DEPARTMENT OF PLANNING AND DEVELOPMENT

July 7, 2004

RE:450 Baxter Blvd. (139 K013)

Title:
LAYOUT AND LIGHTING PLAN

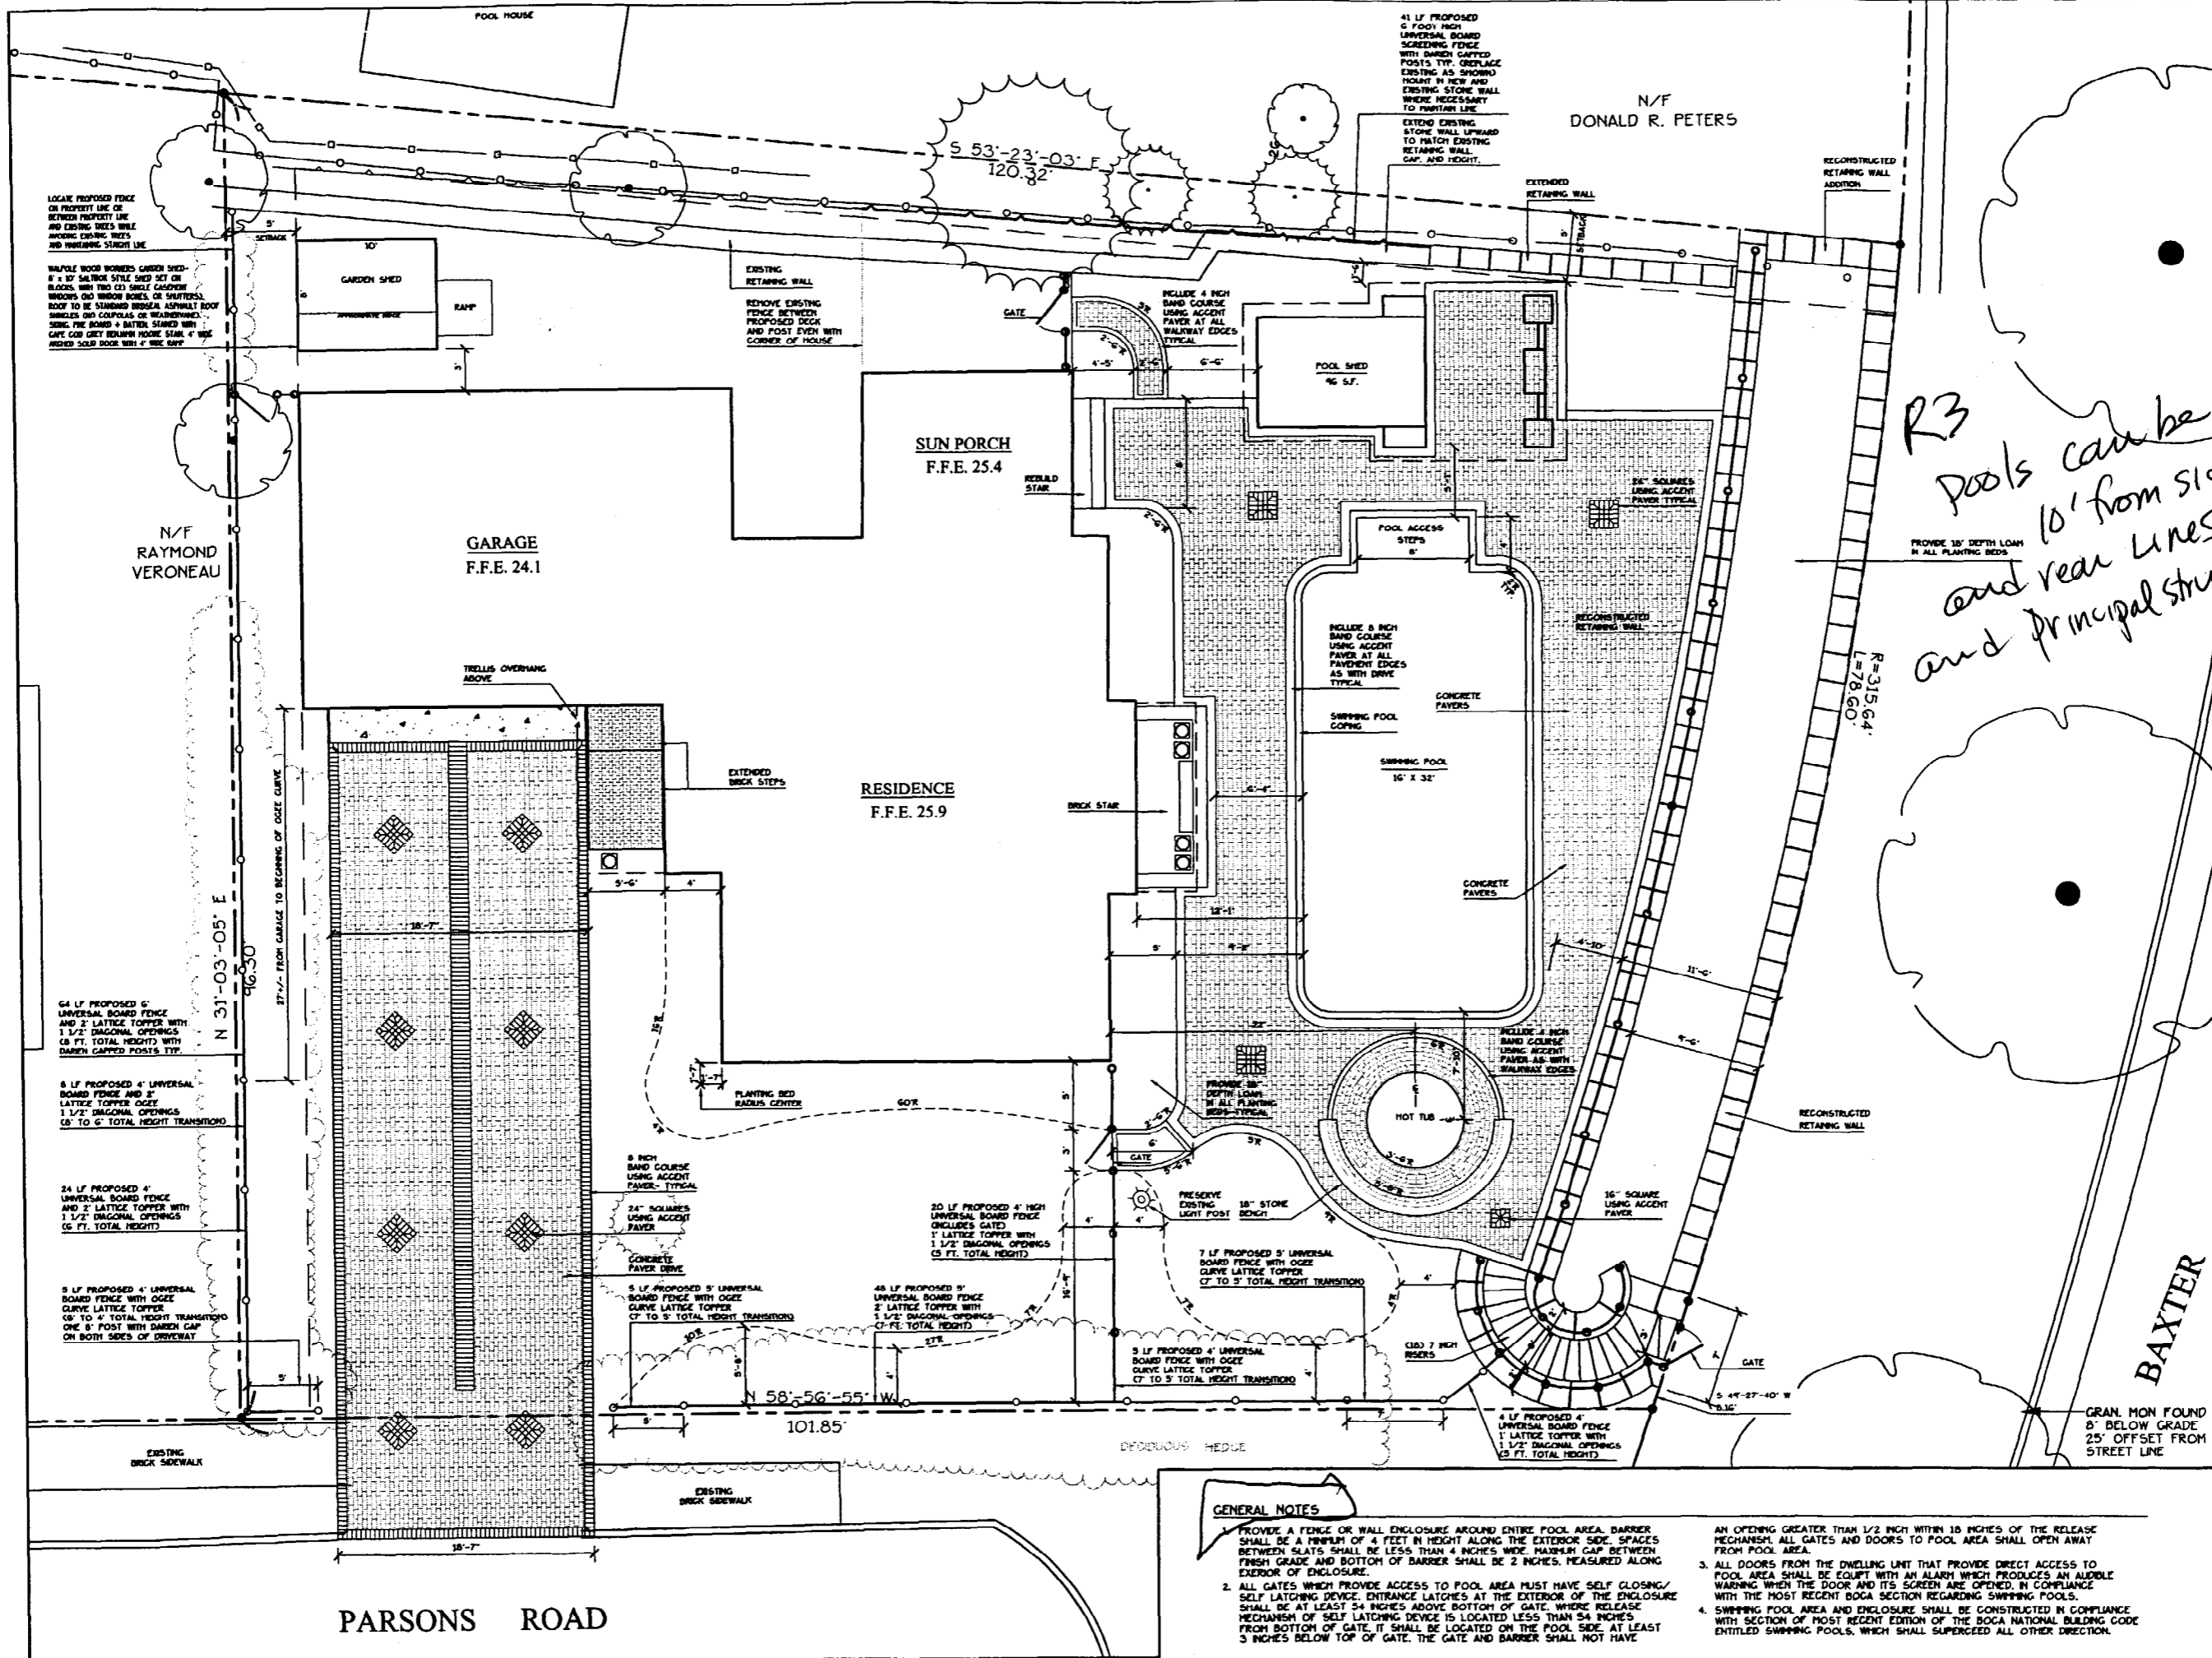
This office has confirmed that a fence in excess of 4 feet in height is scheduled to be installed abutting the Front property line (Parsons Rd.) of the above location within 25 feet of edge of a street. This installation constitutes a violation of 14-426 of the Zoning Ordinance of the City of Portland.

This is a notice is a Stop Work Order. All fence construction activity at the above referenced property must stop immediately. The Fence installation activity cannot commence until such time as a fence that complies with section 14-426 is approved for installation.
